NC DEPARTMENT OF
**HEALTH AND
HUMAN SERVICES**

July 22, 2024

RE: Jersey Mike's Subs
NC Hwy 210
Lillington, NC 28546

This letter acknowledges review of the plan for the above referenced establishment. The revised plans dated 07/16/24, application and email correspondence are approved with the following conditions:

1 FLOOR FINISH PLAN
A1.2 1/4" = 1'-0"

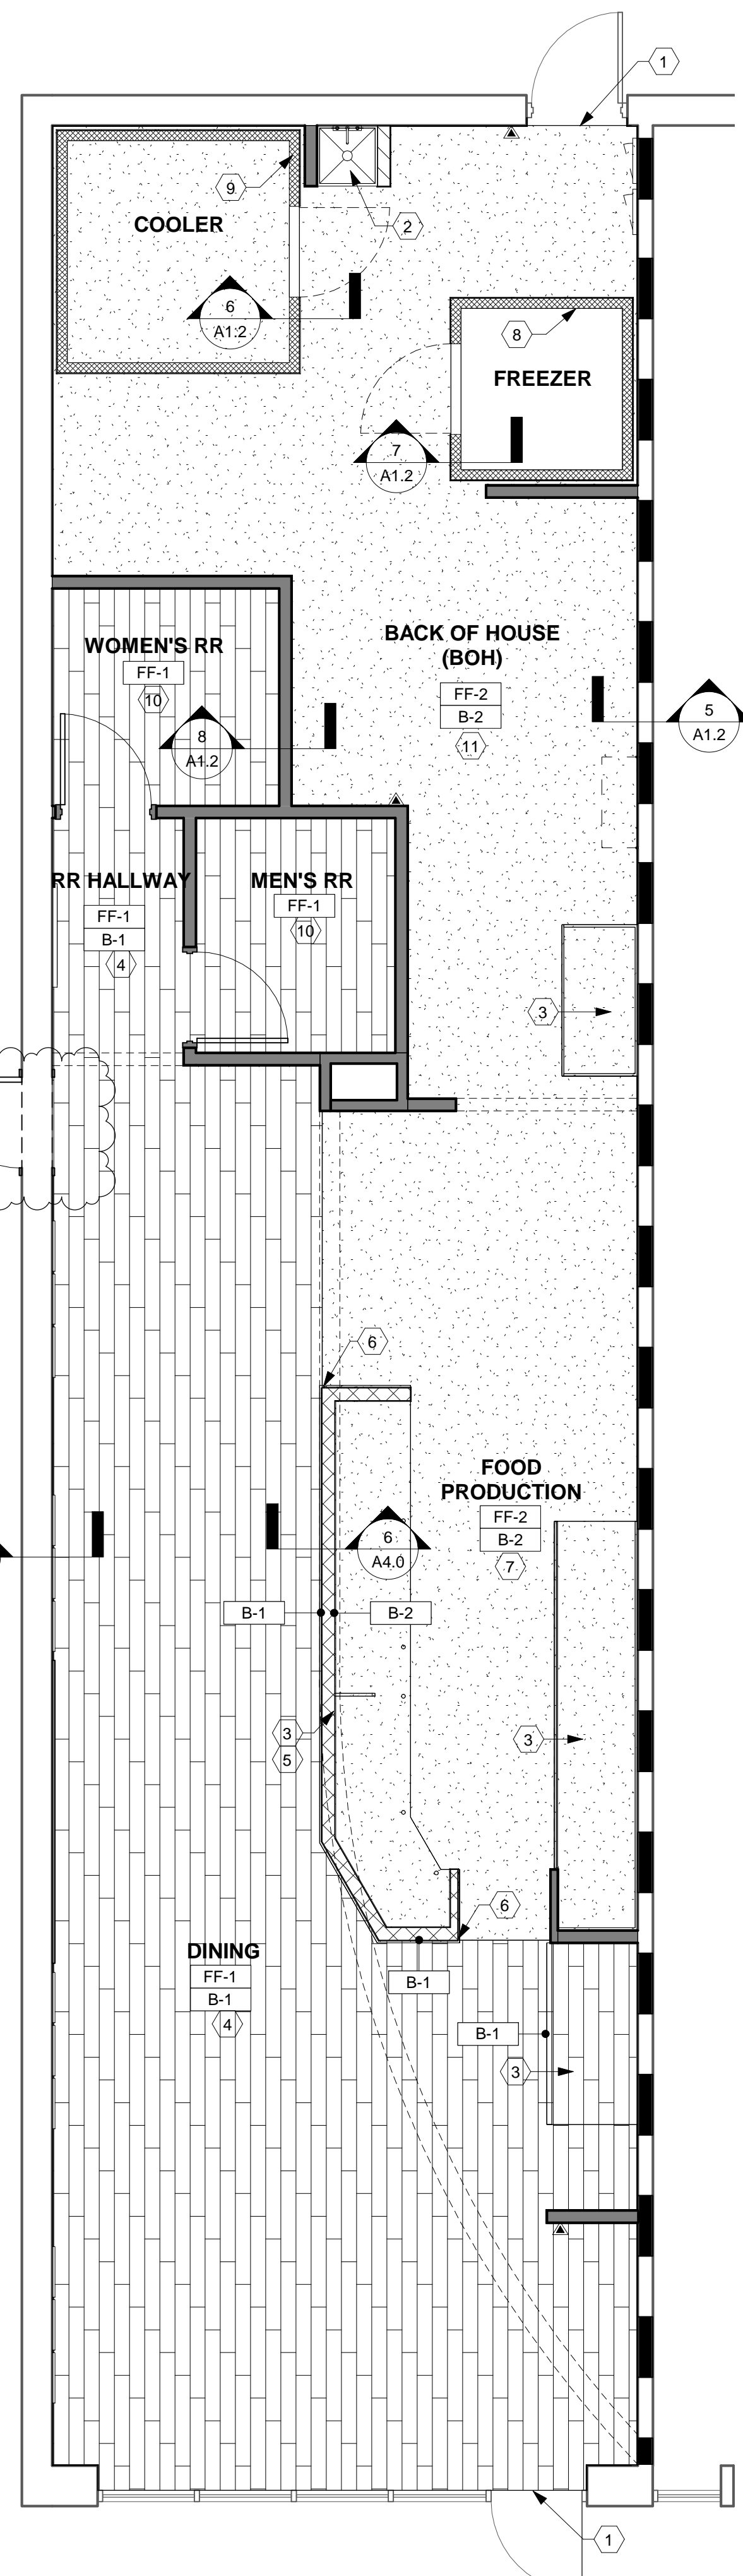
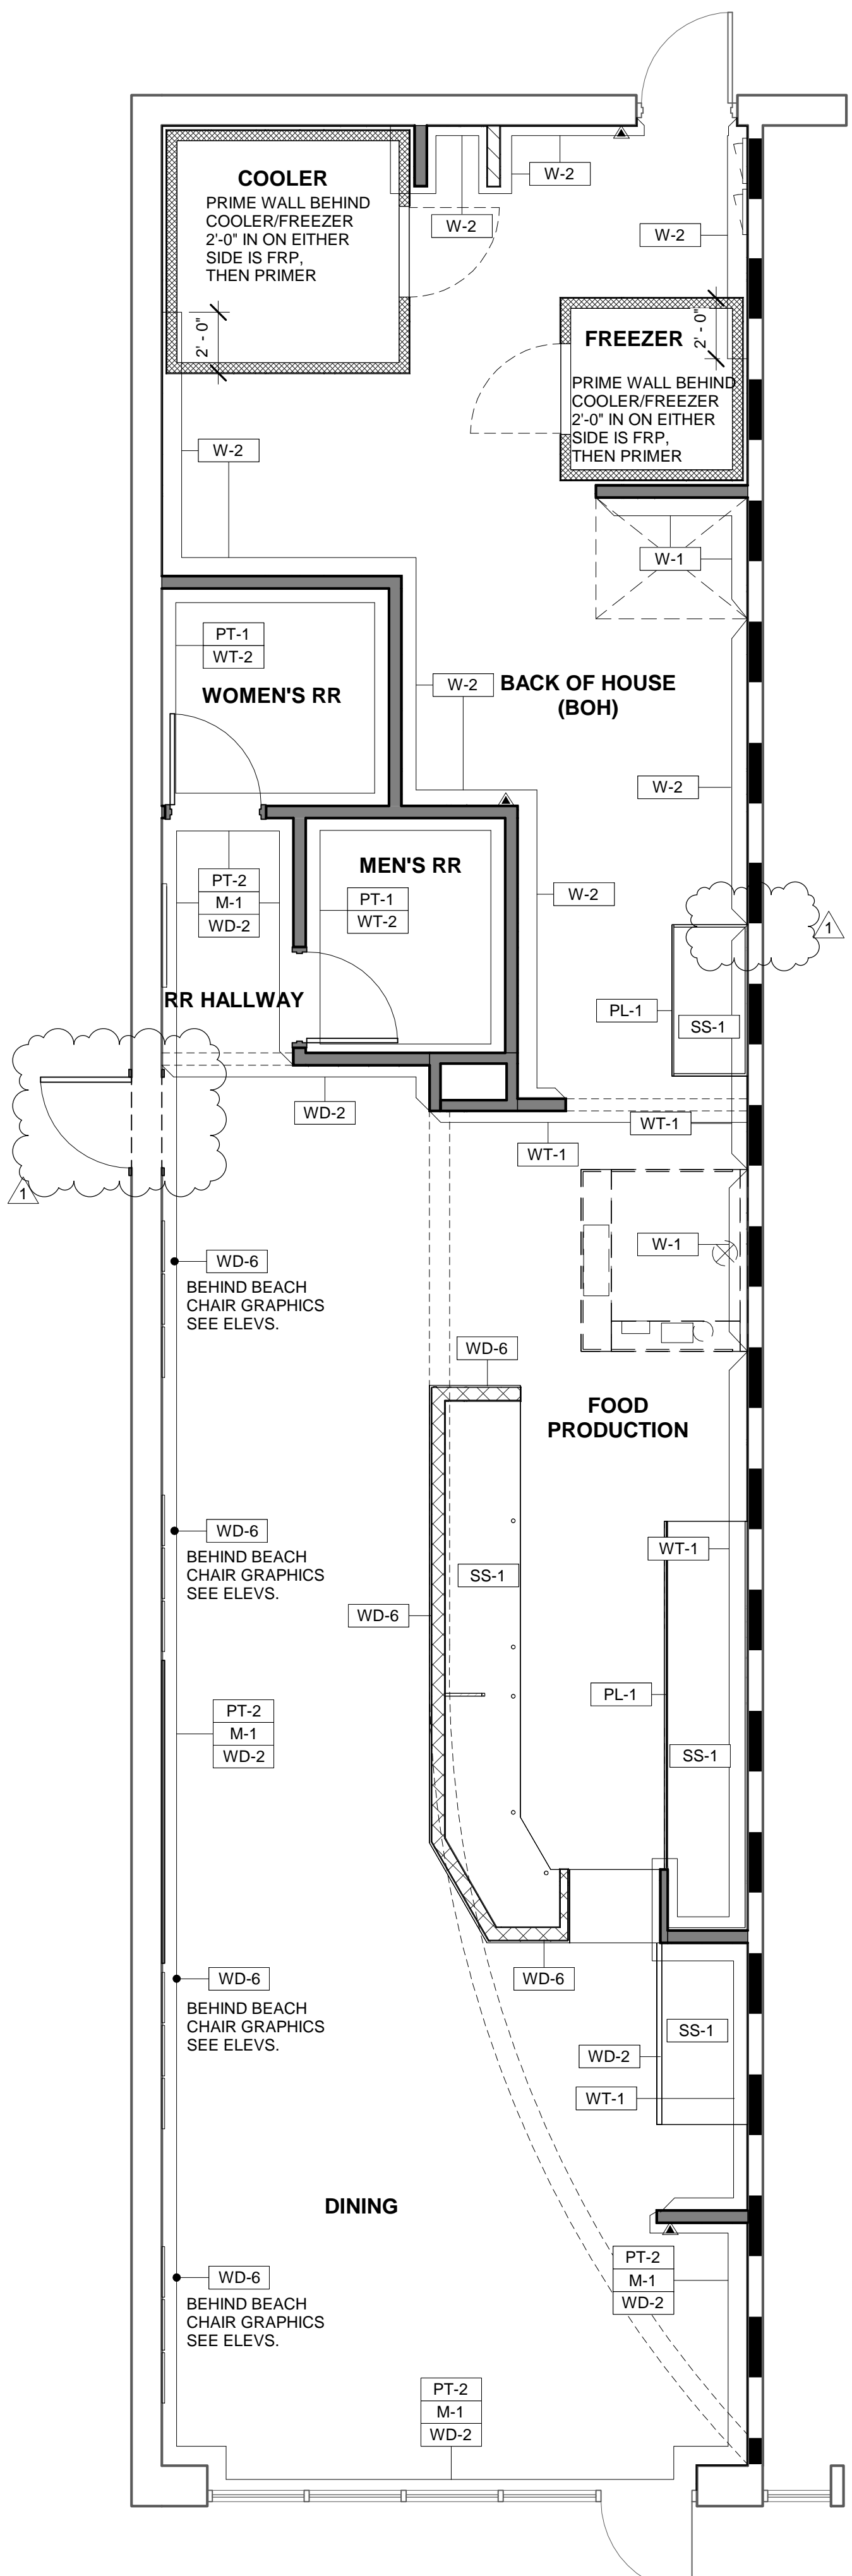
3. Floor, wall, and ceiling finishes must comply with Sections 6-101.11, 6-201.11 and 6-201.13 of the Food Code. Otherwise, the finishes indicated on plan sheets A-110, A-111 and the application are approved. The walk-in freezer is to be enclosed to the side wall and ceiling as shown on plan sheet A.1.3 revised 07/16/24.
